WEST SUSSEX COUNTY COUNCIL CONSULTATION

TO:	Arun District Council FAO:
FROM:	WSCC – Highways Authority
DATE:	24 September 2026
LOCATION:	Burger King (Uk) Ltd Worthing Road Littlehampton BN17 6LE
SUBJECT:	LU/207/26/PL Installation of a drive-through lane to serve the existing Burger King restaurant. This application affects a Public Rights of Way. Is in CIL Zone 4 (Zero Rated) as other development
DATE OF SITE VISIT:	n/a
RECOMMENDATION:	More information

Figure 3.1: Site Layout Plan

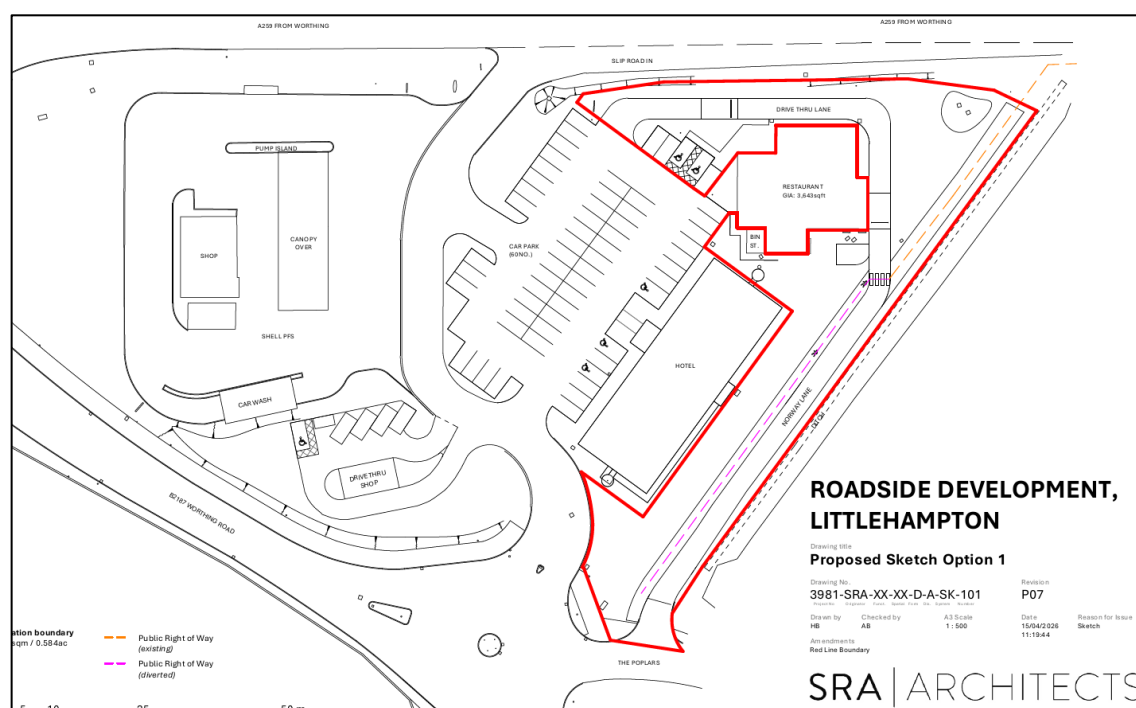
WSCC would like the applicant to provide a visual representation of the drive thru at peak times and how this will impact the car park to ensure the slip road can accommodate the worst case scenario queueing capacity. WSCC need to understand how the queues from the drive thru will impact the A27 slip road into the site, as this is shared with the petrol station, and premier inn.

Please can more information be provide on a plan showing the queue impact of the drive thru at its busiest time be shown on a plan to prove this will not reach the A259.

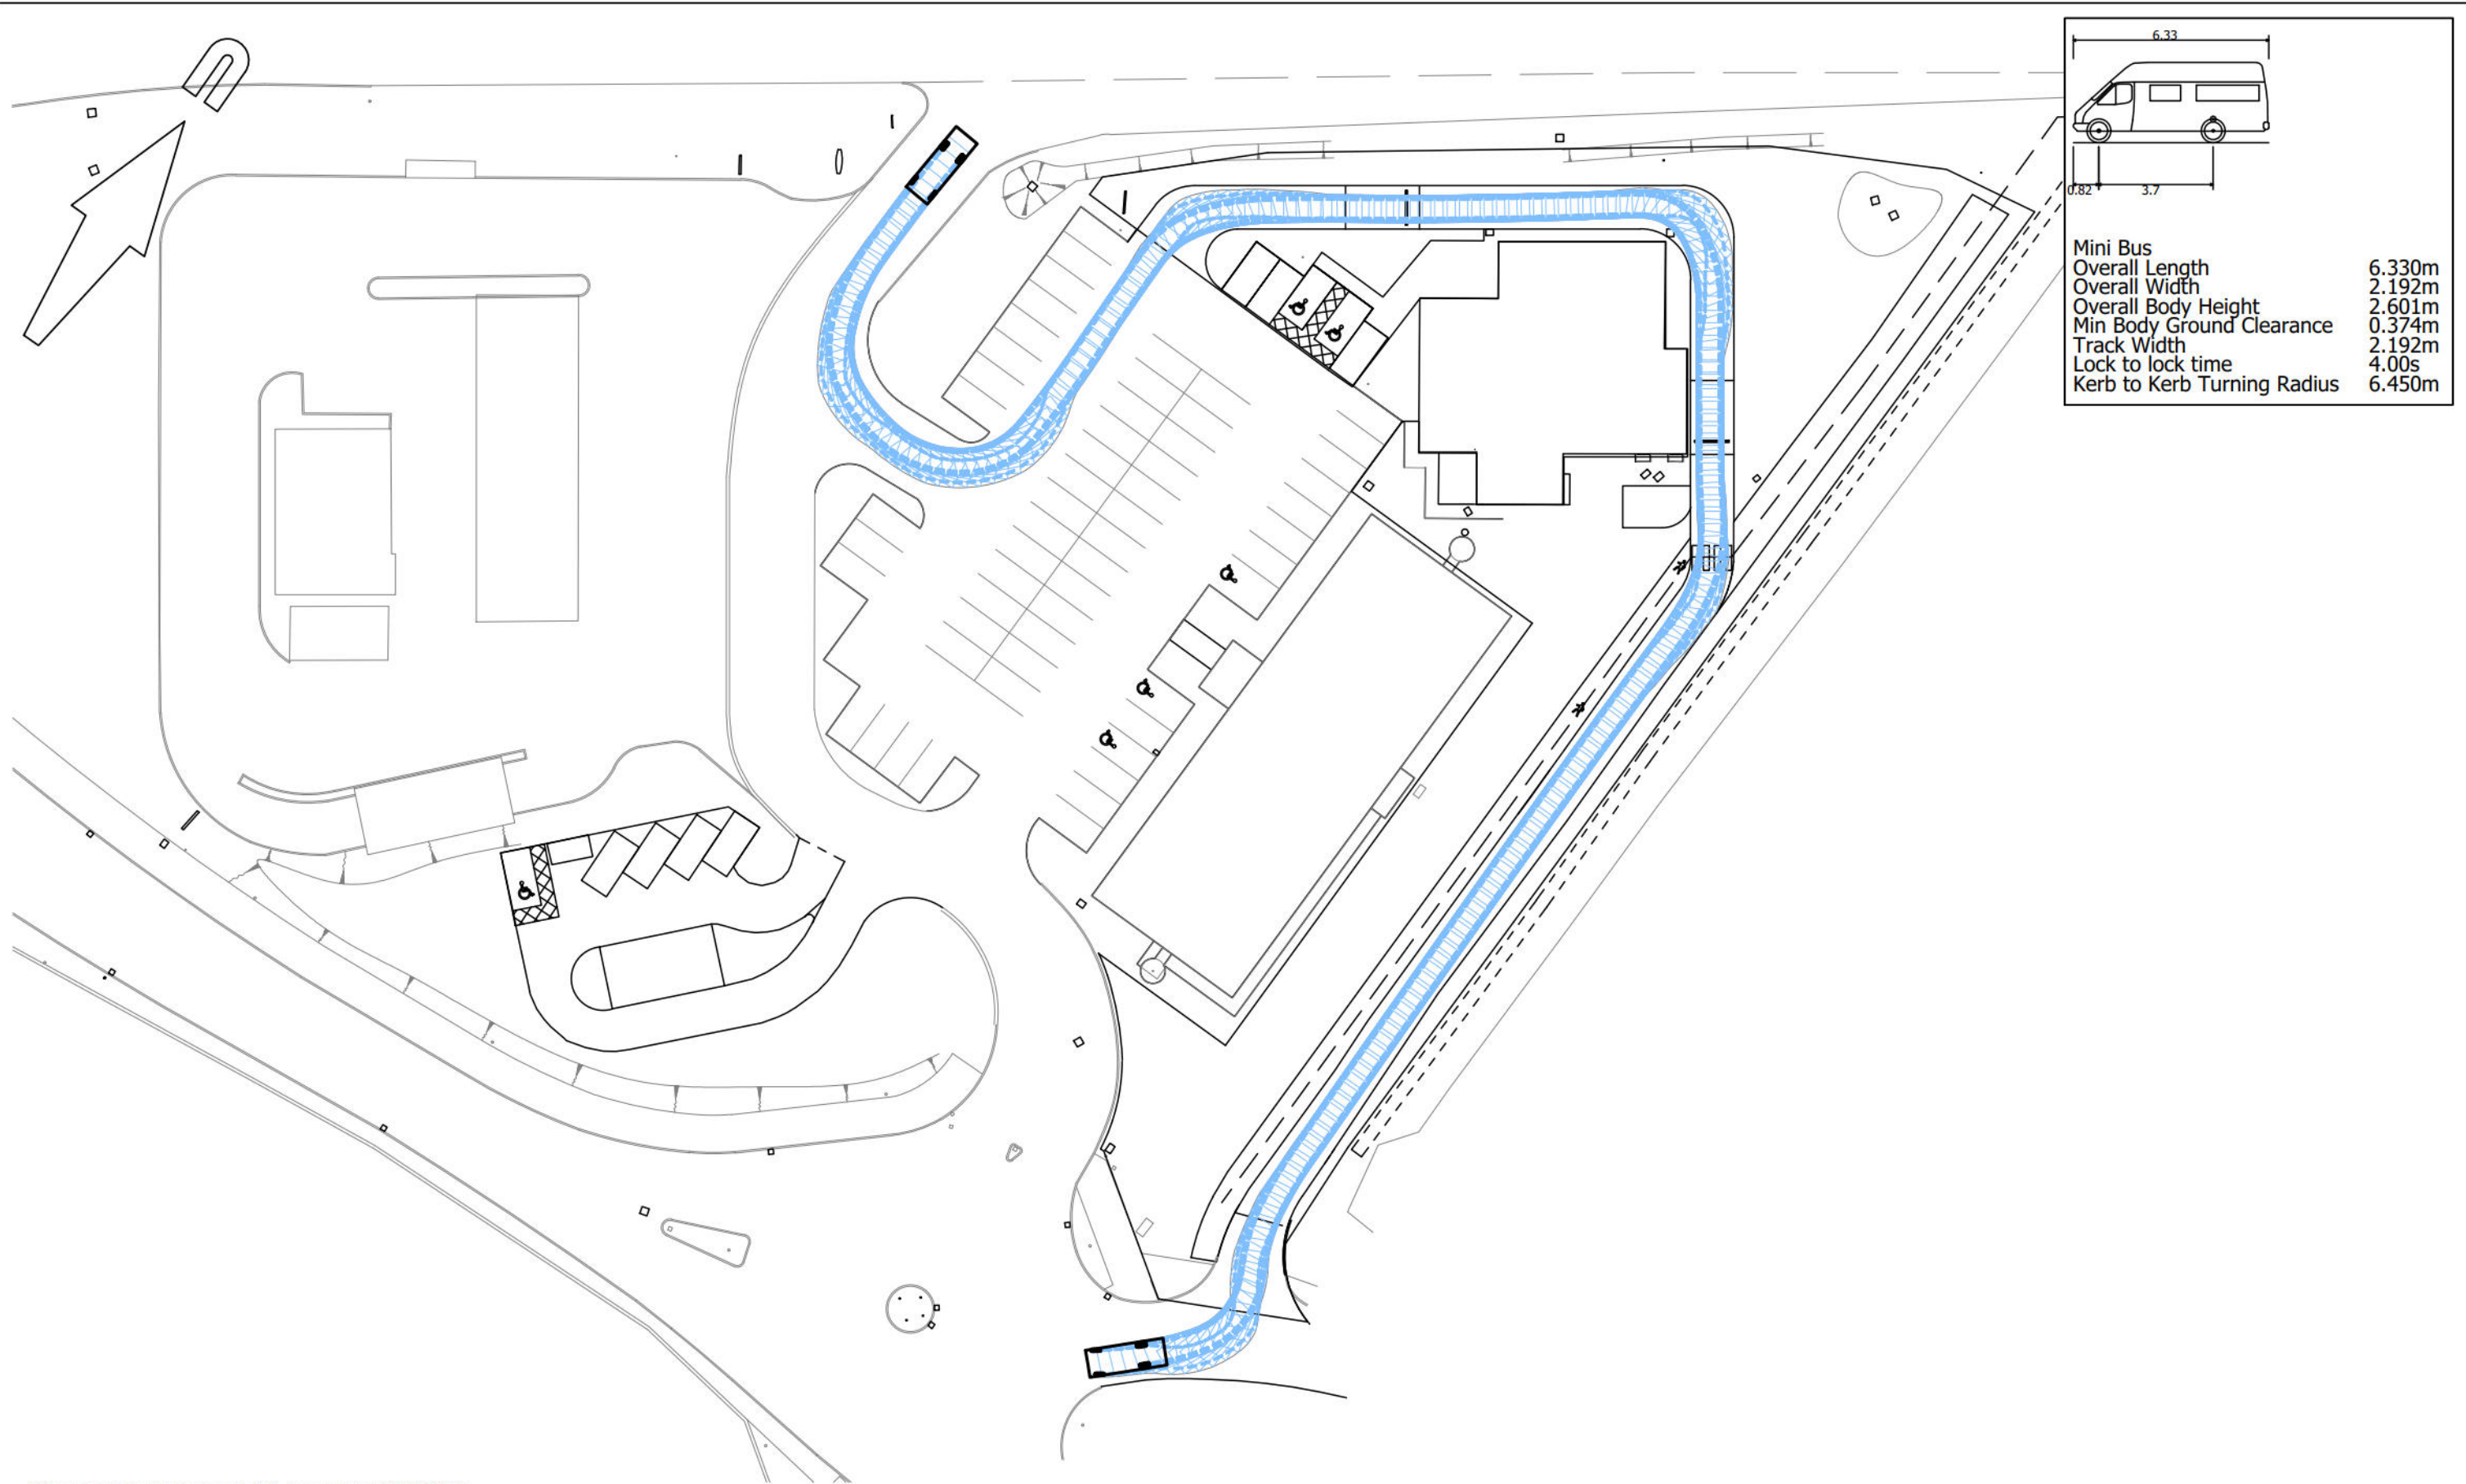
Swept path diagram SPRustingtonBK.1/TK01 shows the swept path of a minibus, using the existing public right of way, known as Norway Lane, that will be used as the main exit route. A new public right of way will be created on the western side of the drive thru lane to connect with the PROW to the north.
